Tel: 01903 737756
Email: planning@arun.gov.uk
www.arun.gov.uk/planning
Please ask for: Breezie Allwright
Email: breezie.allwright@arun.gov.uk
Telephone: 01903 737500
Our Ref: BR/27/26/HH
Your Ref:
Date: 25th February 2026

Application for Planning Permission for Works or Extension to a Dwelling

Development: Dropped kerb and new vehicular access.
Location: 95 Longford Road Bognor Regis PO21 2TA

PROPOSED NEW VEHICULAR ENTRANCE AT 95, LONGFORD. ROAD, BOGNOR REGIS
FOR MR. & MRS. S. BAKER - BROWN.

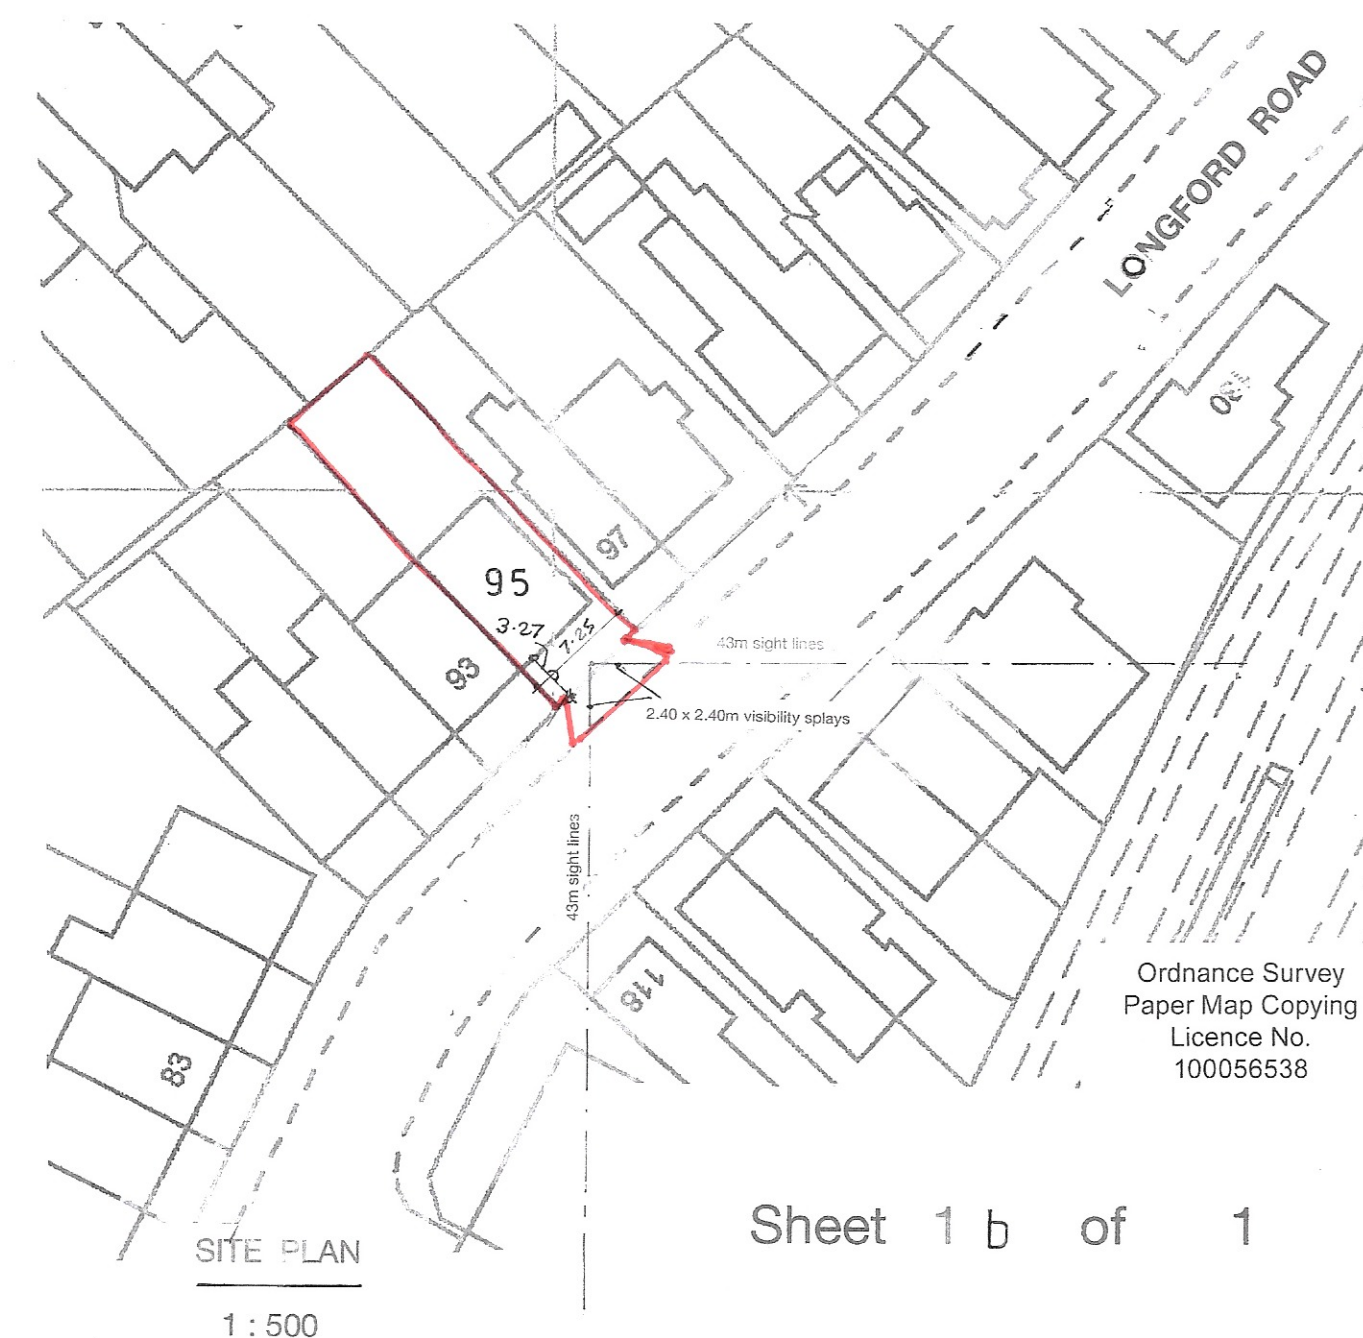
The measurements on the location plan do not align with the annotations and 1:50 scale plan.
